**Consultation Response from KC,
Trees**

**2025/91638 The Mansion House, Heaton Lodge, Bog Green Lane, Colne Bridge, Huddersfield,
HD5 0RF**

Outline application for erection of residential development (5 dwellings)

Date Responded: 03/10/2025

Site plan (1:500)

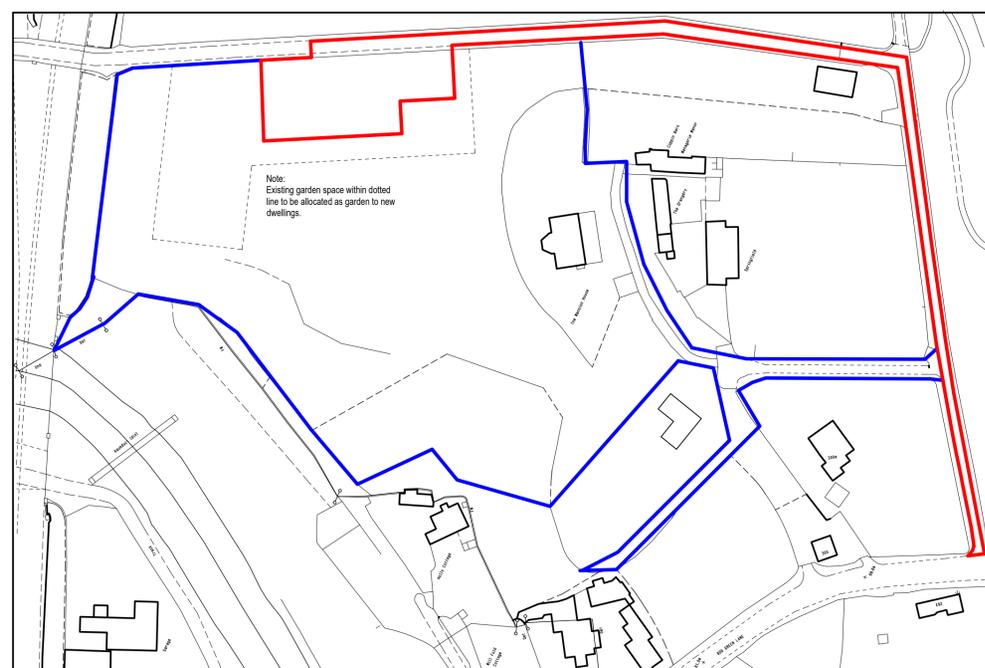
The submitted plans appear that there would be some tree loss around the existing tennis court area as well as some hedge loss within the site and to create the access road. This would broadly be acceptable due to the low amenity value provided by these trees and hedges at this secluded location.

There is scope for 5 dwellings whilst retaining some of these trees however this is something that should be addressed at the design phase.

There is no objection from KC trees to the current proposals as the 5 dwellings looks to be achievable with minimal impact on the existing trees.
